Response to Request of SEARs for SSD-10272349 - GPT Industrial Estate at 784-786 Mamre Road Kemps Creek

From: Melissa Rassack
Sent: Thursday, 5 November 2020 1:14 PM
To: David Schwobel
Cc: William Hodgkinson; Alex Rudd; David Burge; Alejandro Trevino
Subject: RE: Request for input into SEARs - GPT Industrial Estate SSD-10272349
Attachments: 20201030 - UD Comments - Stage 1 Industrial Estate SSD.pptx

Stage 1 - Warehouse 3

E2 CORRIDOR ALIGNMENT PLAN
SCALE 1:500

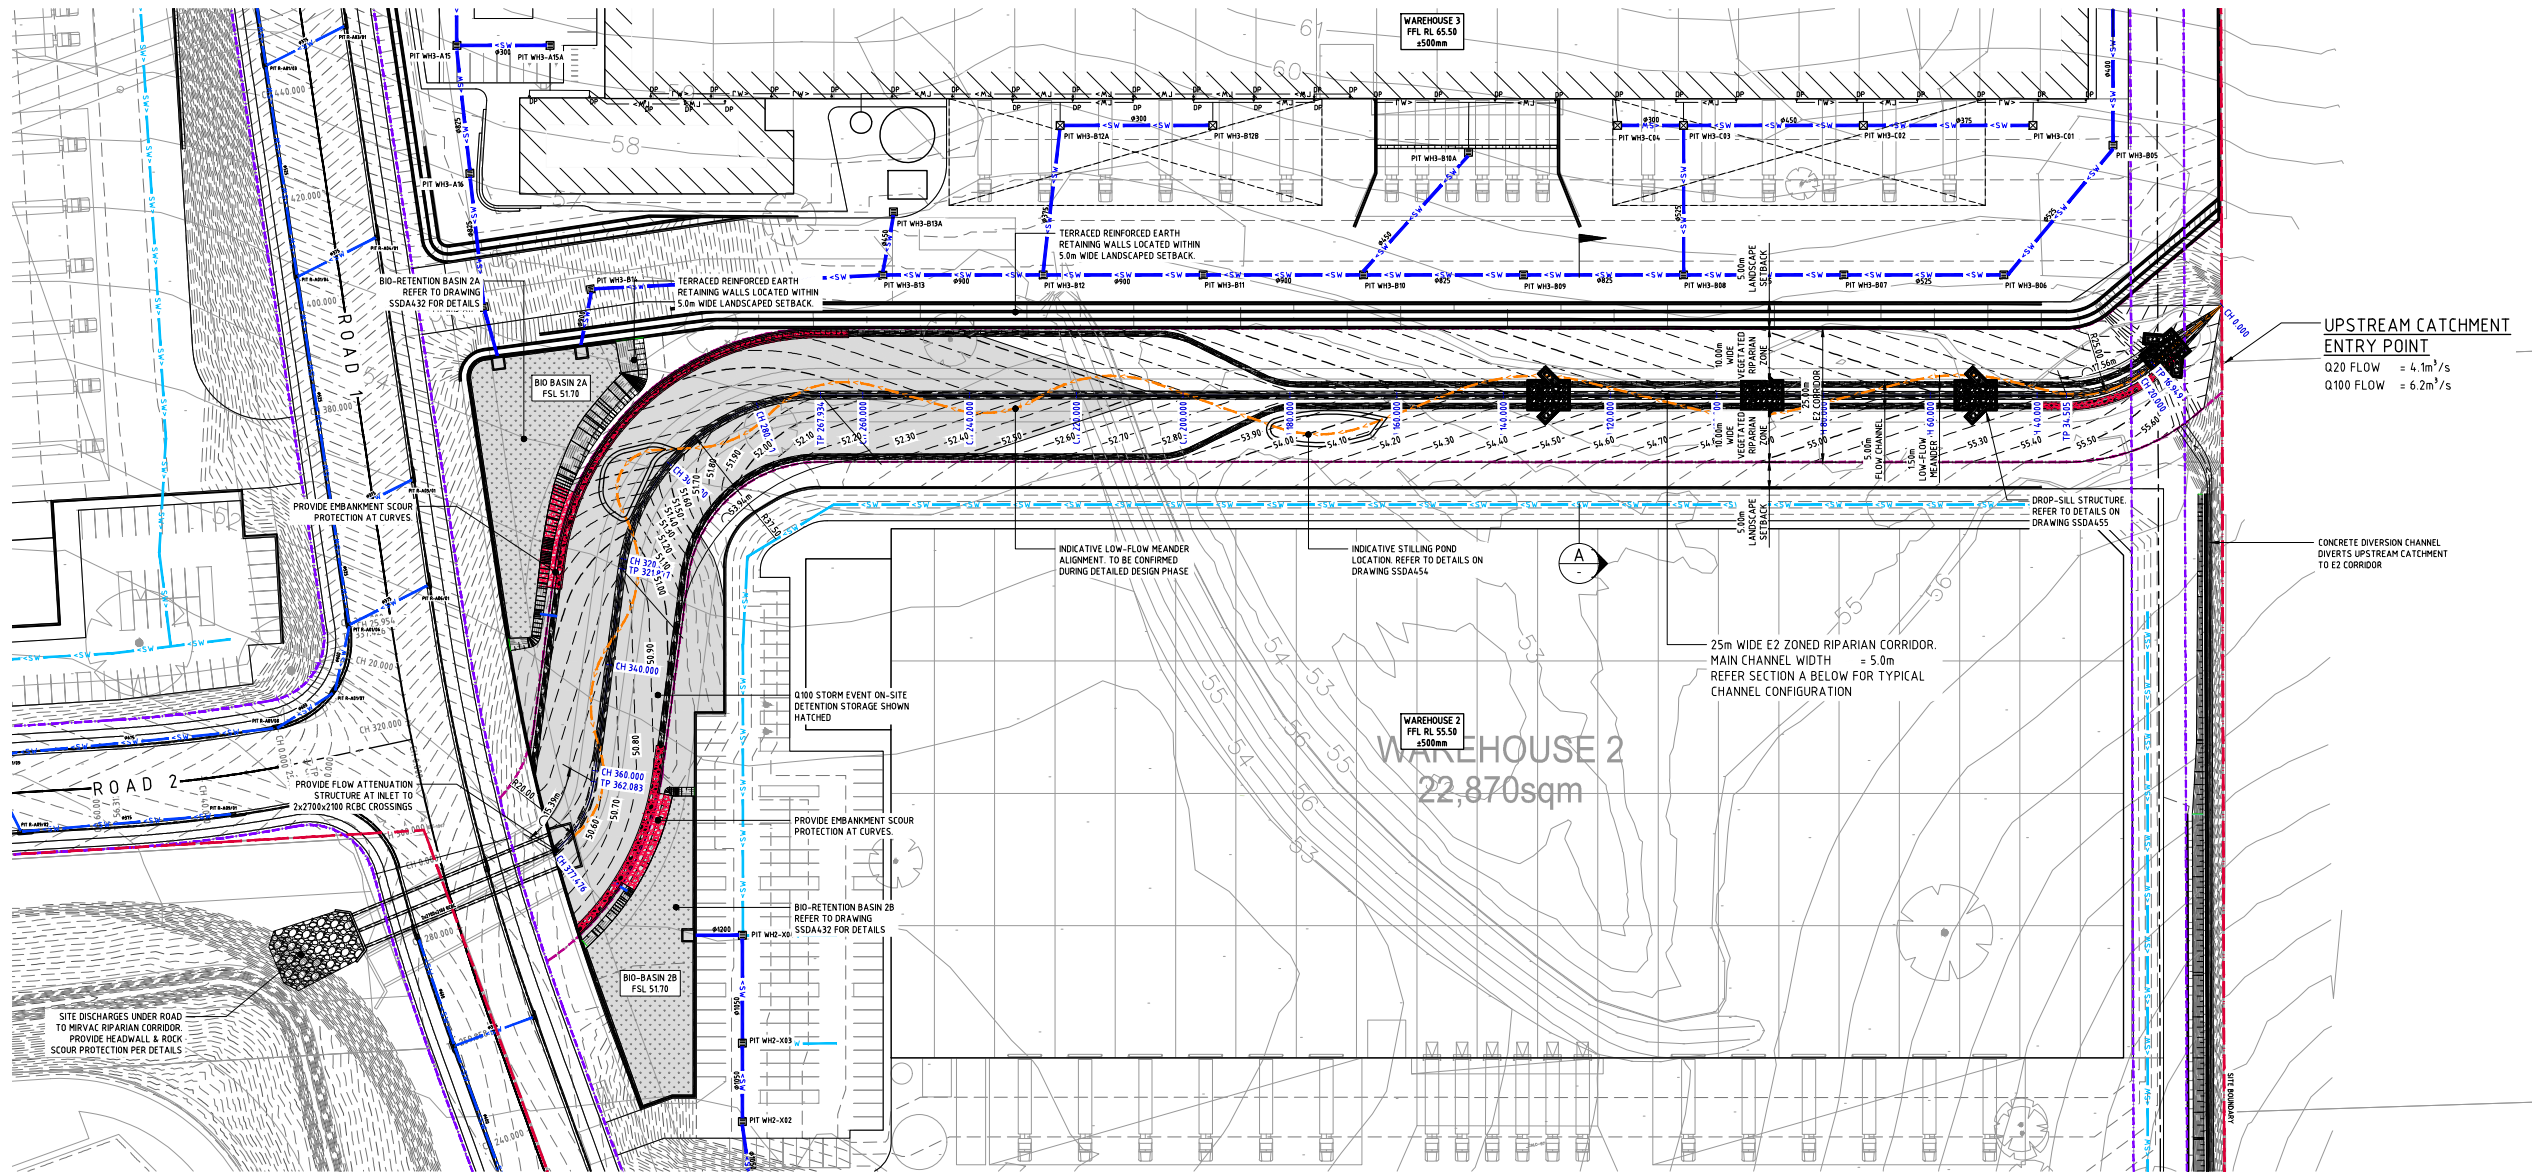
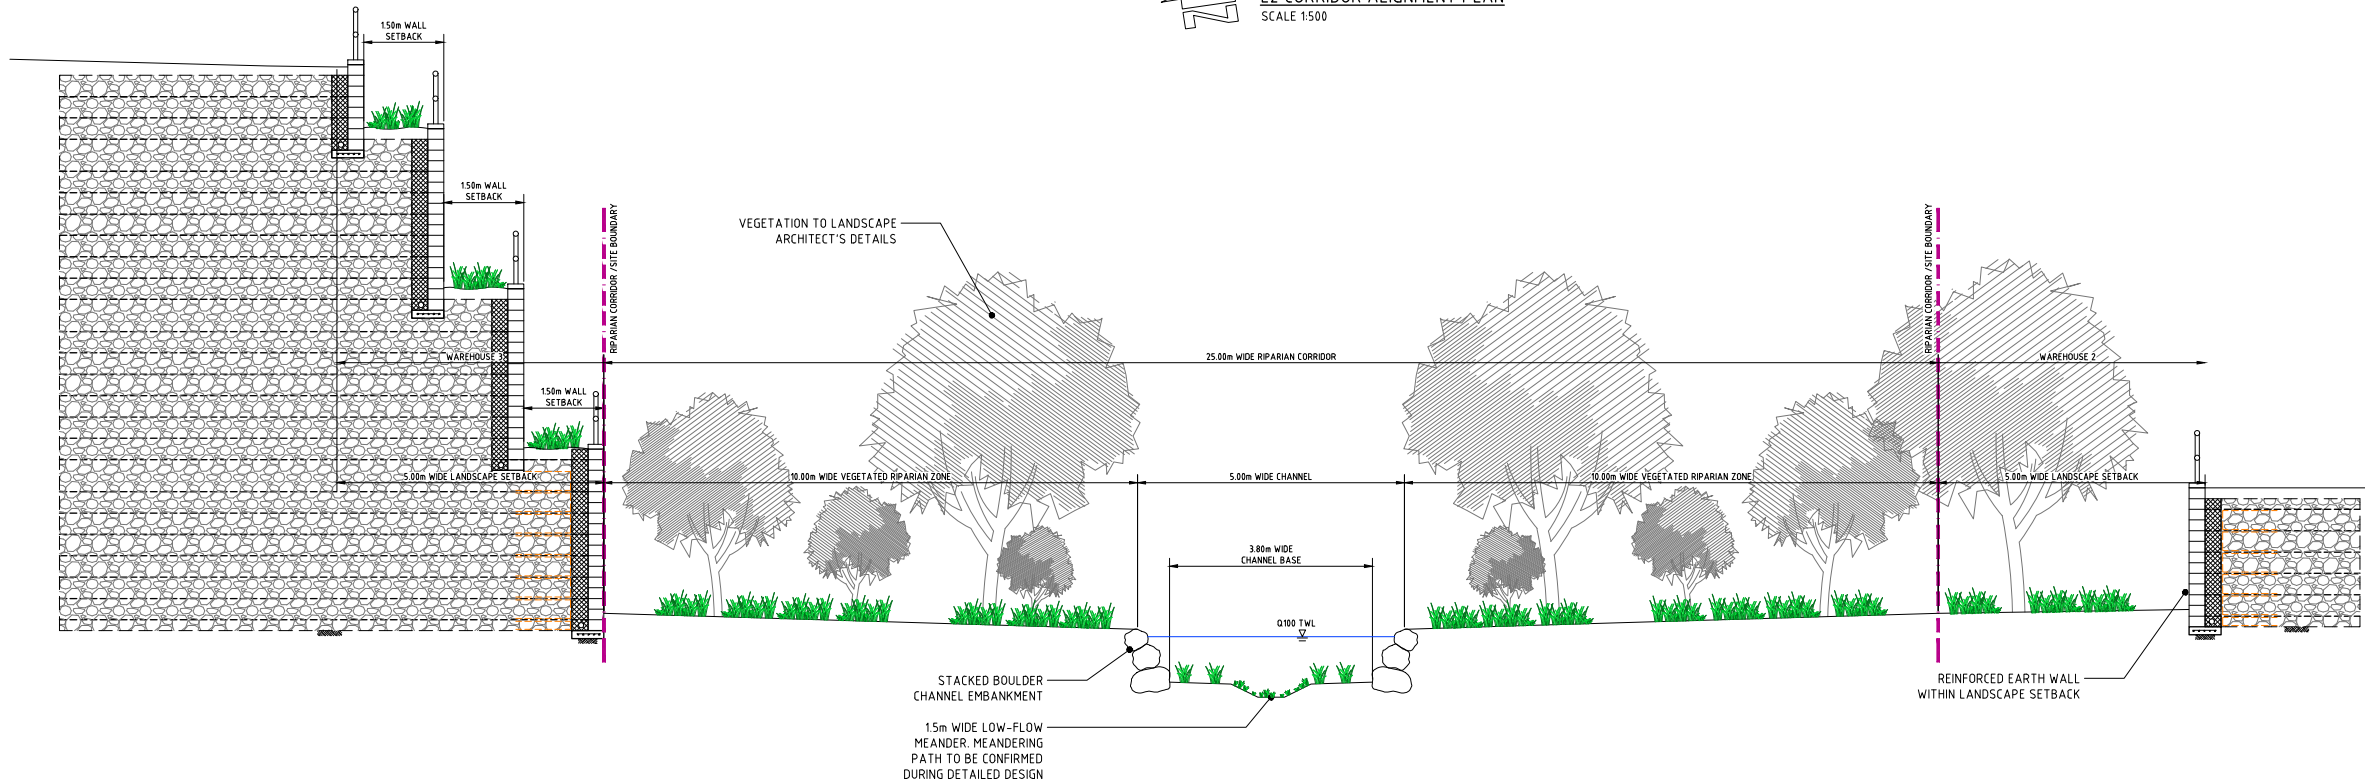
- E2 Zone:** Riparian corridor appears too narrow. Ensure sufficient area is provided to support requirements of the local ecosystem. (to refer to DPIE's public spaces and green infrastructure advice).

- Layout of E2:** The proponent should demonstrate that the proposed geometry changes to the Riparian corridor will address adequate flow of the watercourse. A softer geometry angle is recommended to improve this issue.

- Suggestion to request further detail on the intersection of retaining wall and the Riparian Corridor

DRAWING	DOCUMENT TITLE
MP 00	Location Plan / Cover sheet
MP 01	SSDA Masterplan
MP 02	Estate Works Staging Plan
MP 03	Subdivision Plan
MP 04	Site Analysis Plan
MP 05	Zoning Plan
MP 06	Signage Plan
MP 07	Fire Protection Plan
MP 08	Vegetation Management Plan
MP 09	Fencing Management Plan

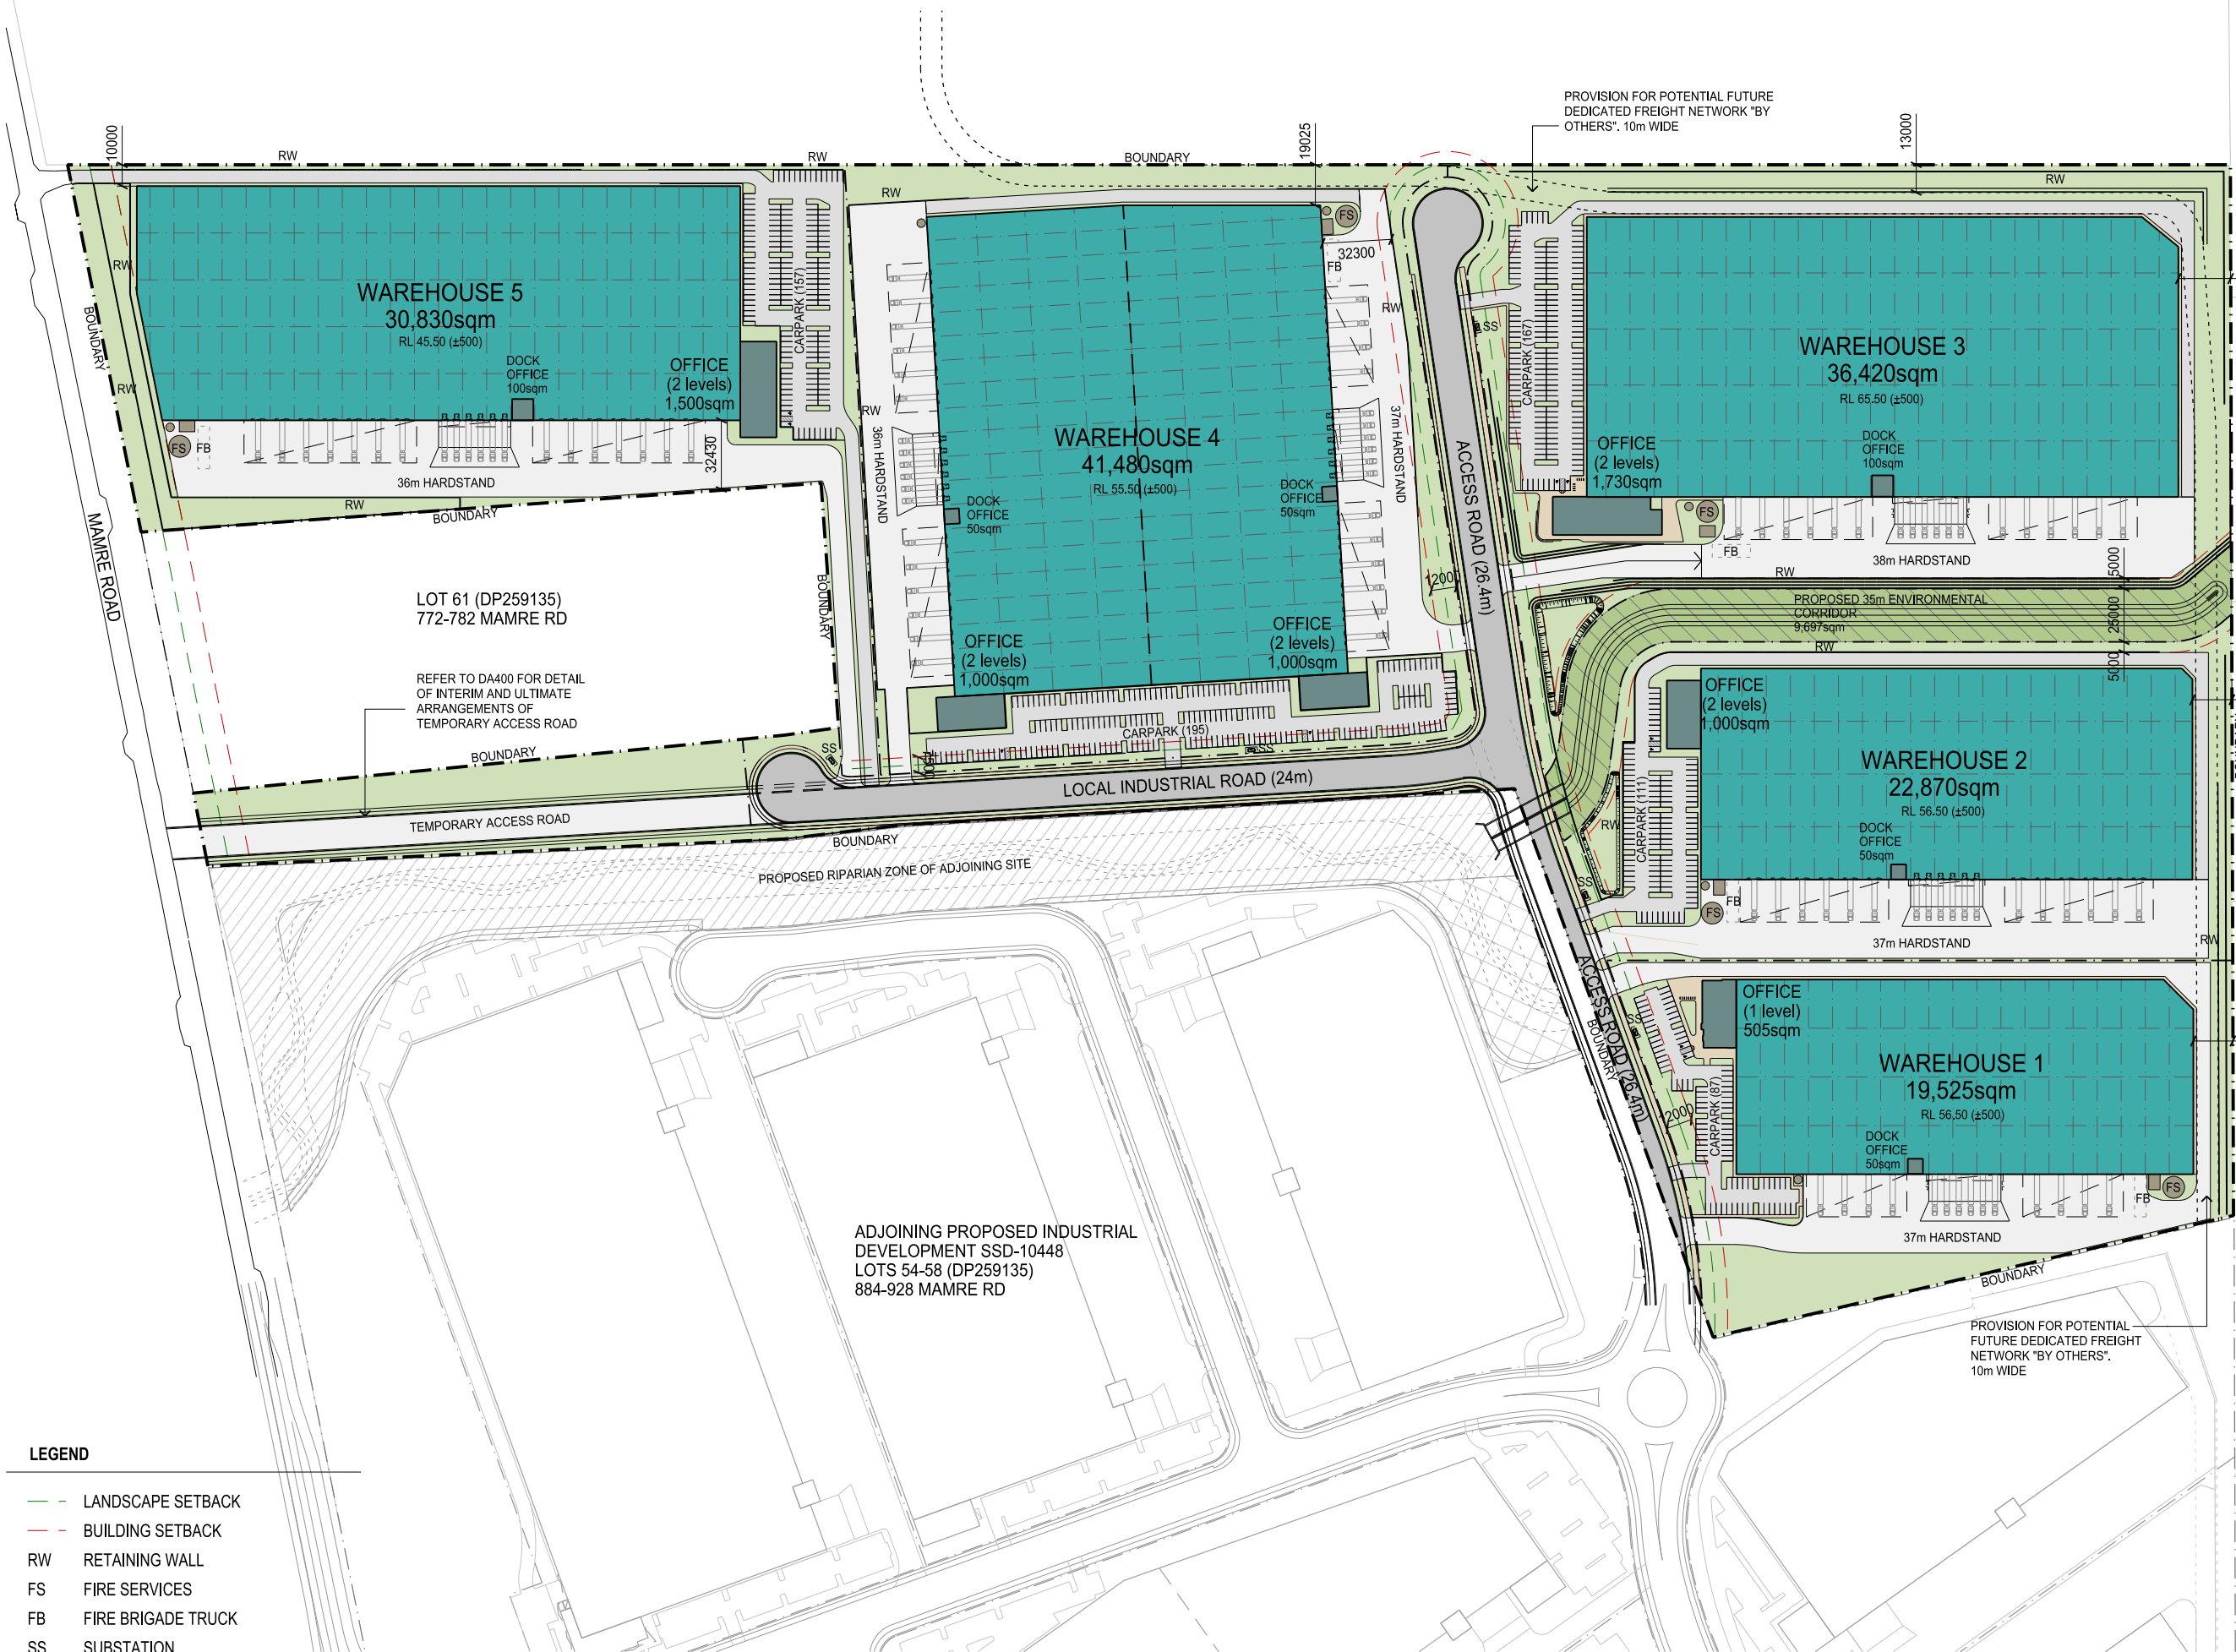
- Council do not support any direct driveway access to Mamre Road. As such, Council does not support the proposed driveway from warehouse 5 to Mamre Road or the proposed temporary access road to Mamre Road.
